Horsham
District
Council

Gatwick Northern Runway Project DCO (Project Reference: TR020005) Deadline 4 Submission (15 May 2024)

**Crawley Borough Council (IP Ref: GATW-AFP107),
West Sussex County Council (IP Ref: 20044715),
Horsham District Council (IP Ref: 20044739) and
Mid Sussex District Council (IP Ref: 20044737)**

2. The Applicant's Response to the Local Impact Reports – West Sussex LIR - Pages 139 –244 [REP3-078]

Figure 4.1: Schematic of Museum Field FCA

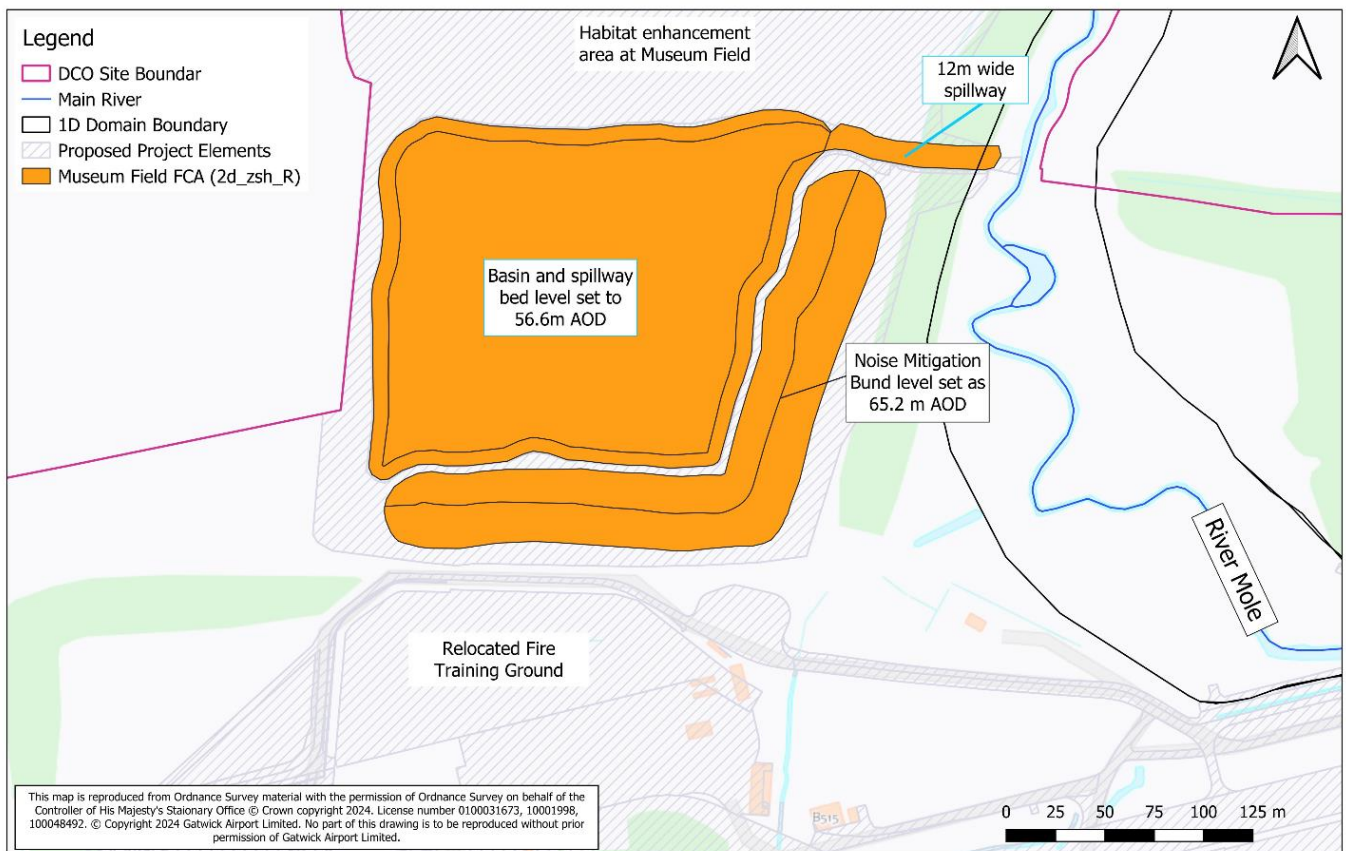
- 2.12 10.1B - There is a generic statement within the Water Environment Chapter [APP-036] which states that the connection between the Museum Field Flood Compensation Area and the River Mole will be undertaken using soft engineering, however, this is a generic statement and the Applicant may state this issue can be taken care of at the detailed design phase. This is considered one of the most important aspects of the river engineering and the fluvial mitigation strategy proposed by the Applicant because if the method of connection is not robust enough this will lead to further environmental degradation and possible migration of the watercourse. The Authorities would like to be informed, engage, and agree with the Applicant at this stage what soft engineering technique will be applied.
